CITY OF ALBUQUERQUE

October 7, 2024

Re: Nobis Rehab Hospital
1100 Woodward PI NE
Traffic Circulation Layout
Engineer's/Architect's Stamp 10-3-24 (J15D053)

Based upon the information provided in your submittal received 10/7/24, the above referenced plan cannot be approved for Building Permit until the following comments are addressed:

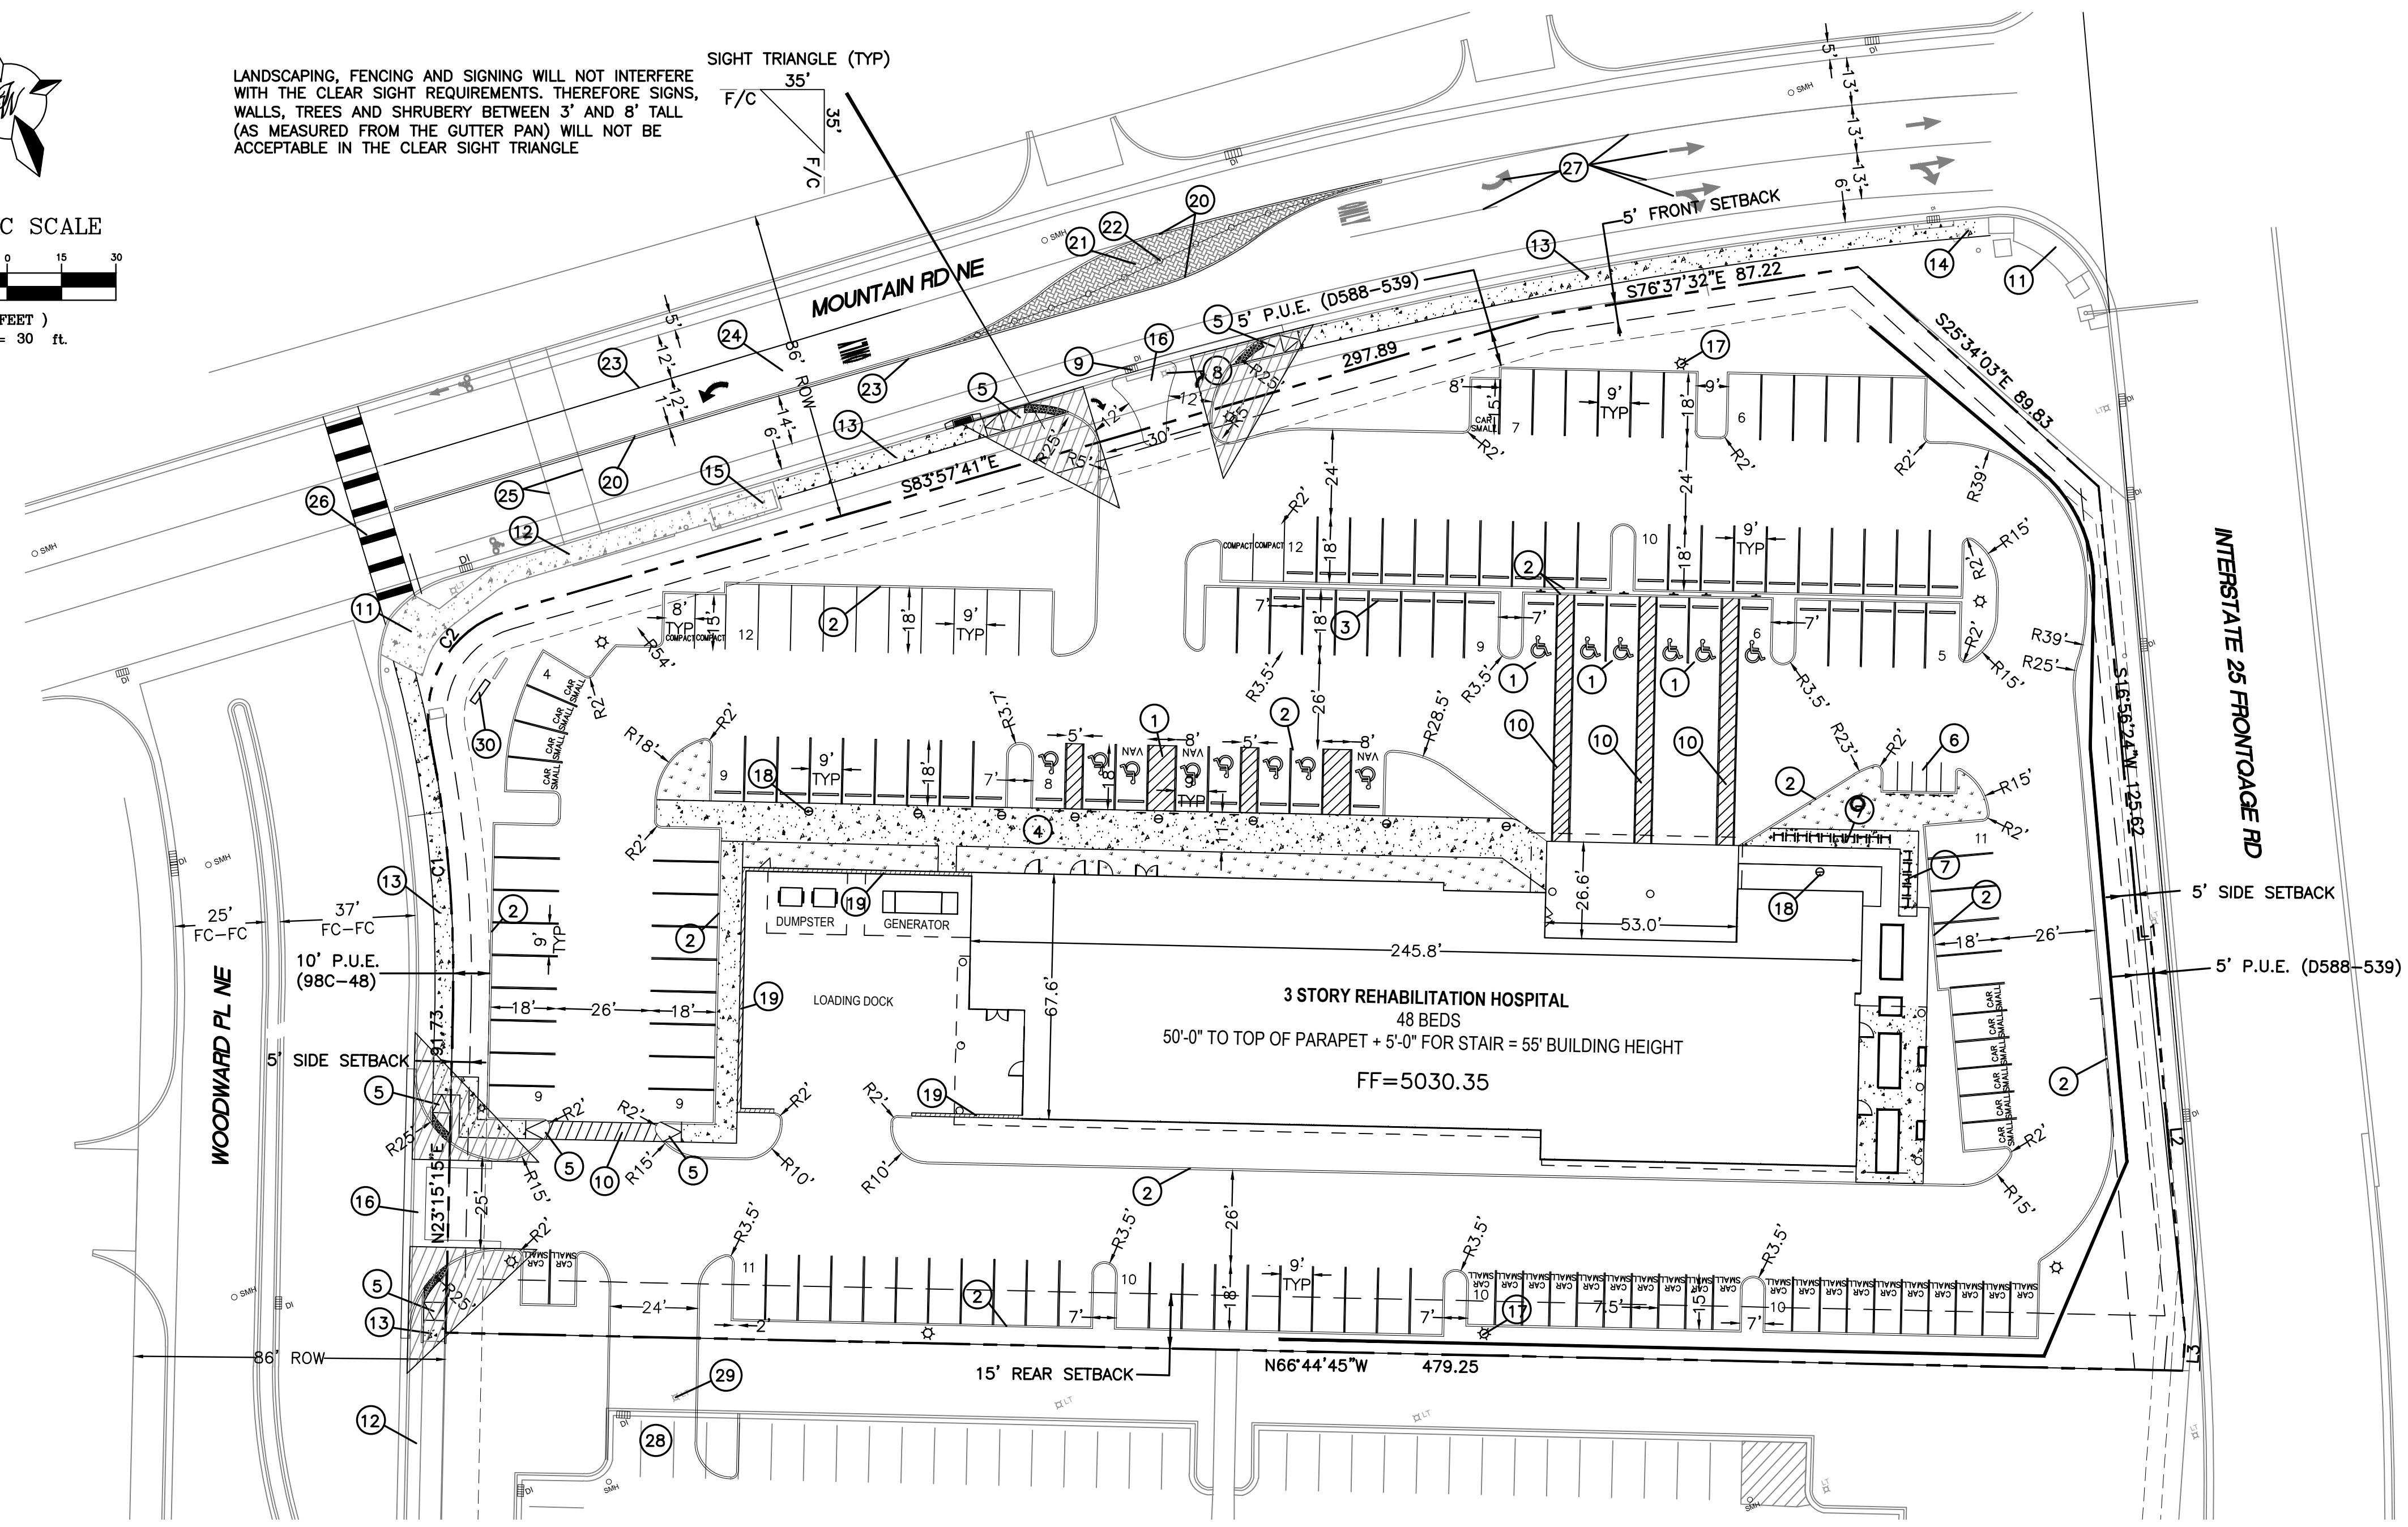
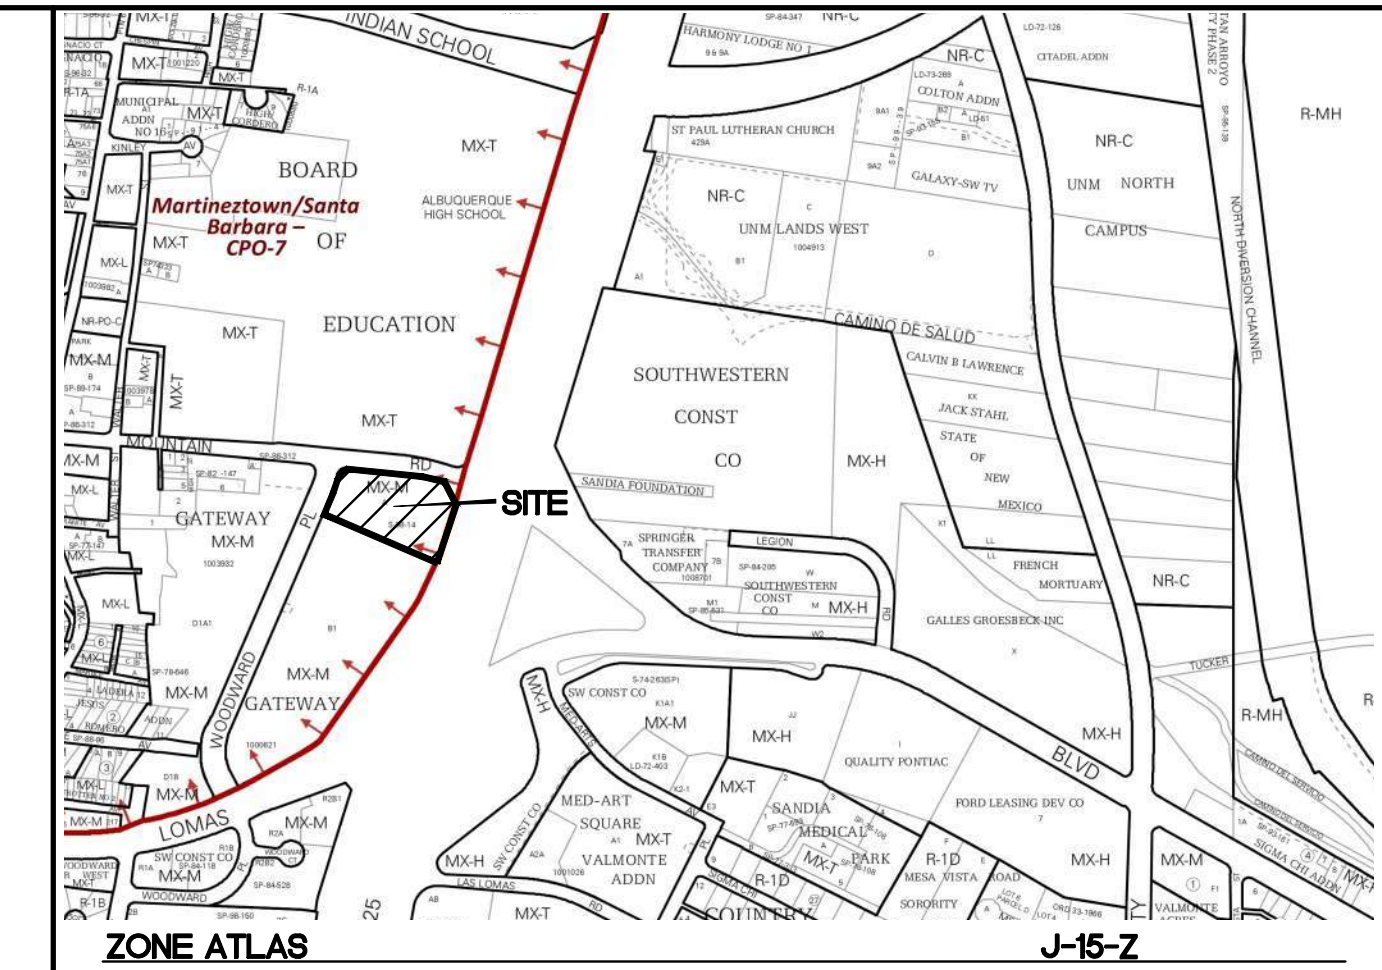
1. Label the compact parking spaces by placing the words "**COMPACT**" on the pavement of each space.
2. The ADA access aisles shall have the words "**NO PARKING**" in capital letters, each of which shall be at least one foot high and at least two inches wide, placed at the rear of the parking space so as to be close to where an adjacent vehicle's rear tire would be placed. (66-1-4.1.B NMSA 1978)
3. ADA curb ramps must be updated to current standards and have truncated domes installed.
4. Add a detaild drawing for the plan view for bike racks showing all the dimensions

5. Per the DPM, a 6 ft. wide ADA accessible pedestrian pathway is required from the public sidewalk to the building entrances. Please clearly show this pathway and provide details.

6. Per DPM, a 6 ft. wide ADA accessible pedestrian pathway is required from the ADA parking stall access aisles to the building entrances. Please clearly show this pathway and provide details.
7. Sidewalk width should be 6 ft along Mountain Rd and 5-6 ft of buffer /landscape.

8. Provide approval of solid waste dept and fire marshal.
9. All one-way drives shall have "One Way" and "Do Not Enter" signage and pavement markings. Please show detail and location of posted signs and striping.
10. Add the following note to the plan: "Landscaping and signage will not interfere with clear sight requirements. Therefore, signs, walls, trees, and shrubbery between 3 and 8 feet tall (as measured from the gutter pan) will not be acceptable in the clear sight triangle."

11. Add a note stating "All broken or cracked sidewalk must be replaced with sidewalk and curb & gutter." A build note must be provided referring to the appropriate City Standard drawing.
